**CM/19/26/PL - Baird Business Park, Grevatt's Lane, Littlehampton
BN17 5RE**

Erection of replacement commercial building, parking and other associated infrastructure, including new attenuation pond. This application is in CIL Zone 5 (Zero Rated) as other development.

PL- Consultation- WSCC Drainage response

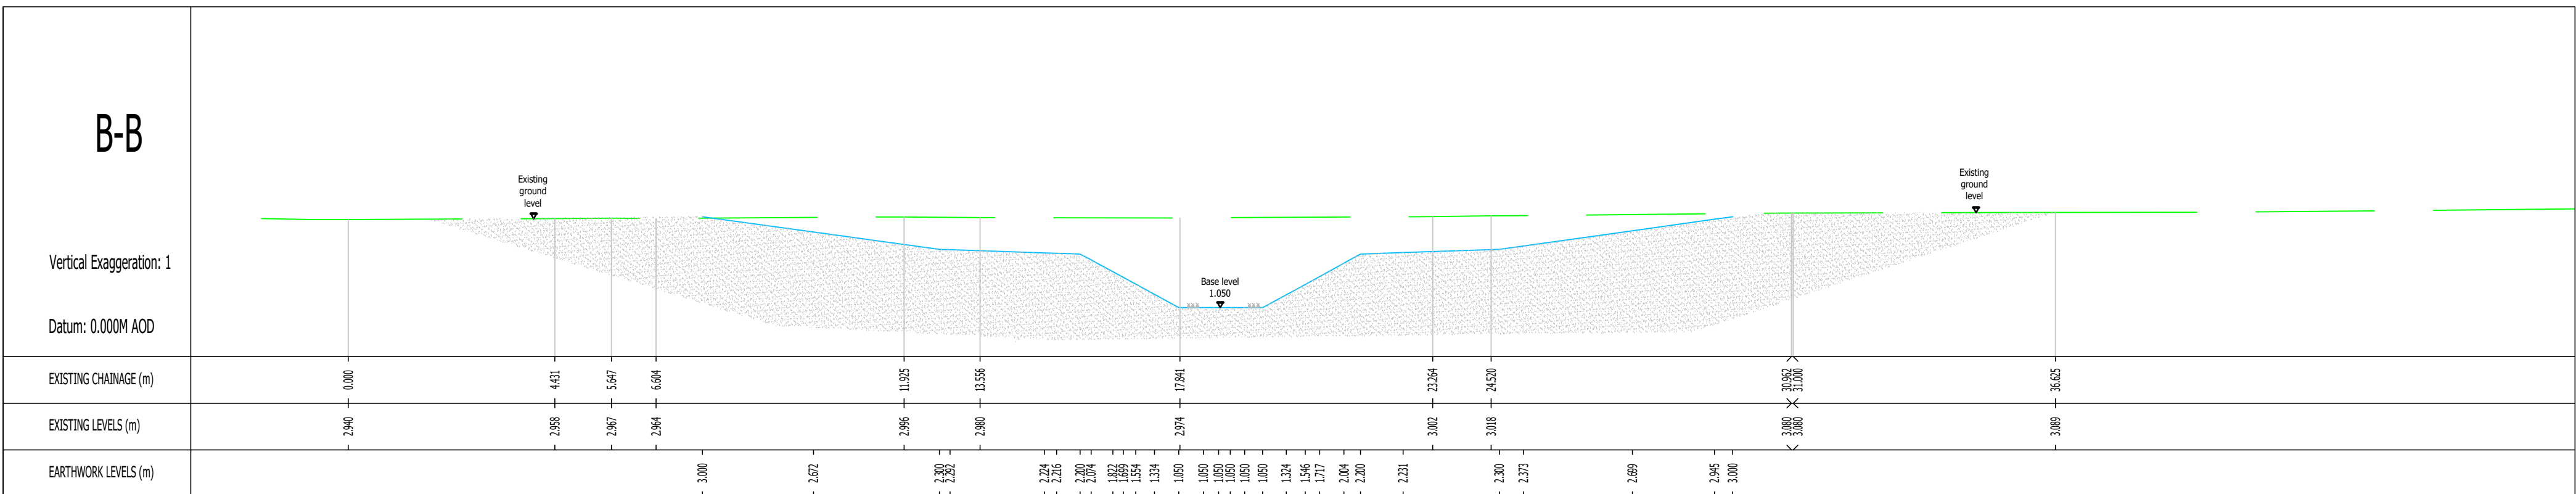
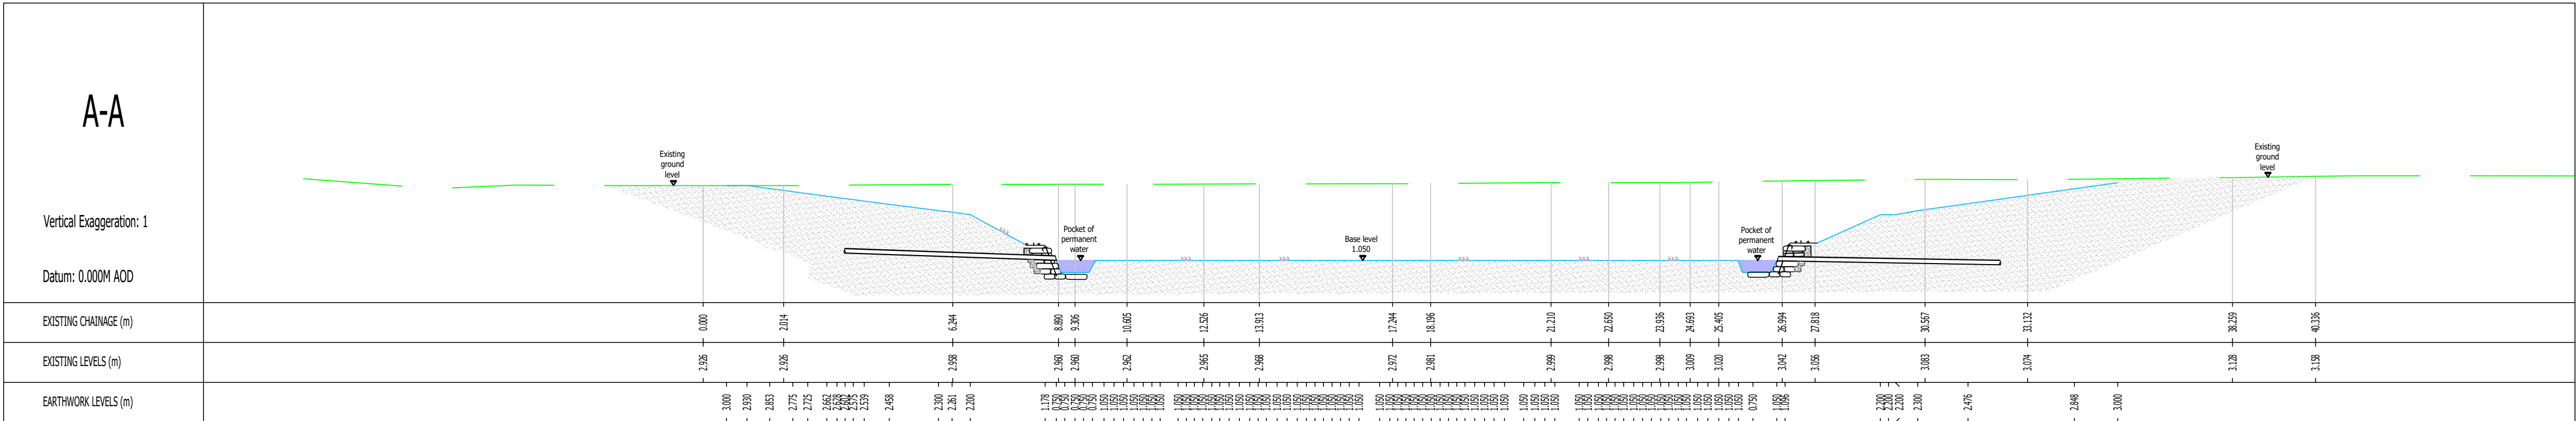
4. Level of detail design. For a full application the status of design would not be expected as preliminary. Plans should be sufficiently detailed (at or near construction) and be referenced and labelled accordingly.
